From: Juan Baeza
Sent: 28 June 2018 13:13
To: Planning.Responses
Subject: WA/33/18/OUT

Subject: Spindlewood

I am dealing with a re-consultation of planning application WA/33/18 however I am unable to respond fully as there is still information missing that I require. The applicant has now provided swept path diagrams for a refuse vehicle but I am still unsure of the visibility splays and the actual speed of the road. I asked for a speed survey and visibility splays taken to the nearside kerb. Will these be provided as I have no other comments other than the ones I made previously asking for these things.

Drawing No.
DPA 13

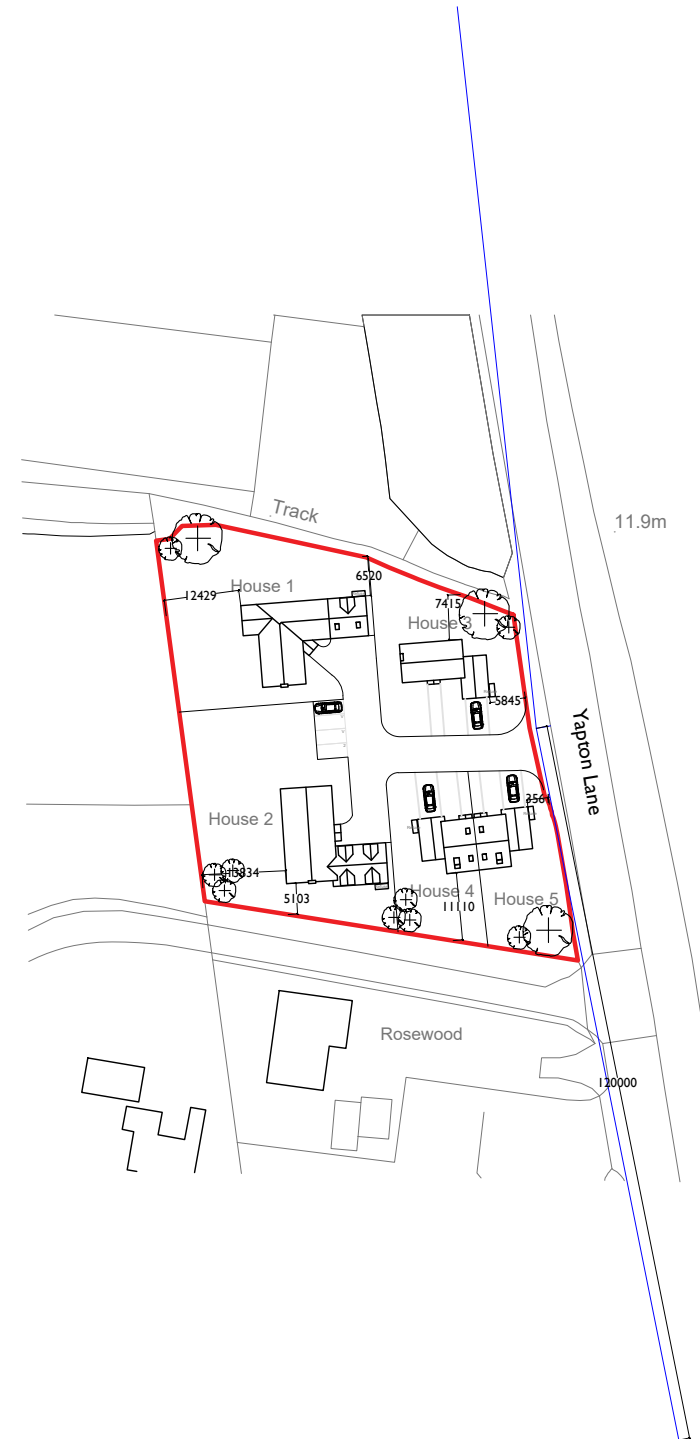
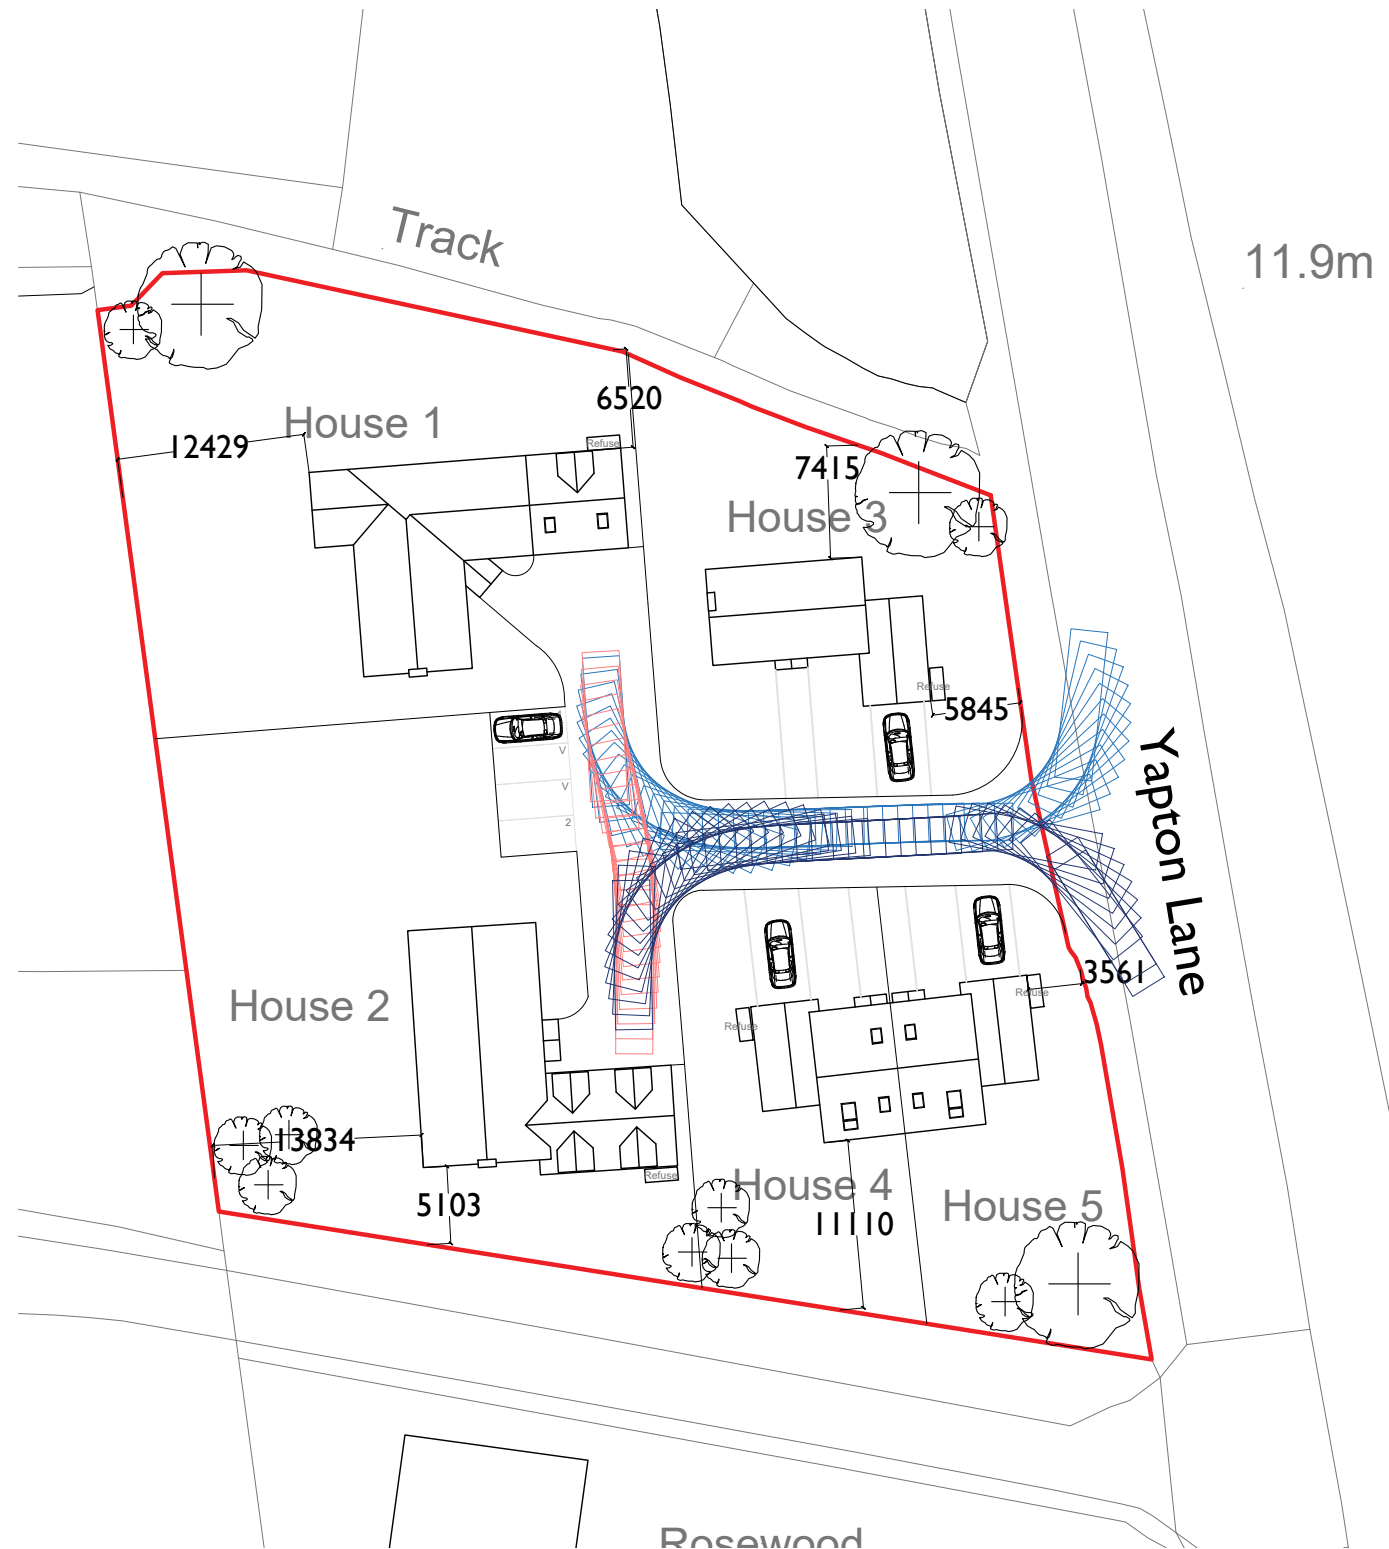
Many thanks for this. Based on this drawing DPA 13 – Visibility splay, we can accept the access in this position with these splays. One other question, are the splays drawn to the nearside kerb or off set by 1m? It seems that the northern splay is to the centre line? This would be acceptable as it is not the leading splay but I do need this confirmed. Do the splays go over third party land at all? It doesn't look like they do but can you confirm this please?

I can see a blue line on the plan but it doesn't have any annotation on it to say its 120m. Furthermore is this set back 2.4m or 2m? This should be shown as otherwise its open to interpretation.

If the 120m visibility can be provided in both directions then this will be acceptable for a 40mph road if set back 2.4m and no speed survey will be required.

I can confirm the splay to the North is more towards the centre line. The splays do not go over third party land at all.

Please find attached DPA 13 – Visibility Splay. This is show with dimensions of 2.4m and 120m.
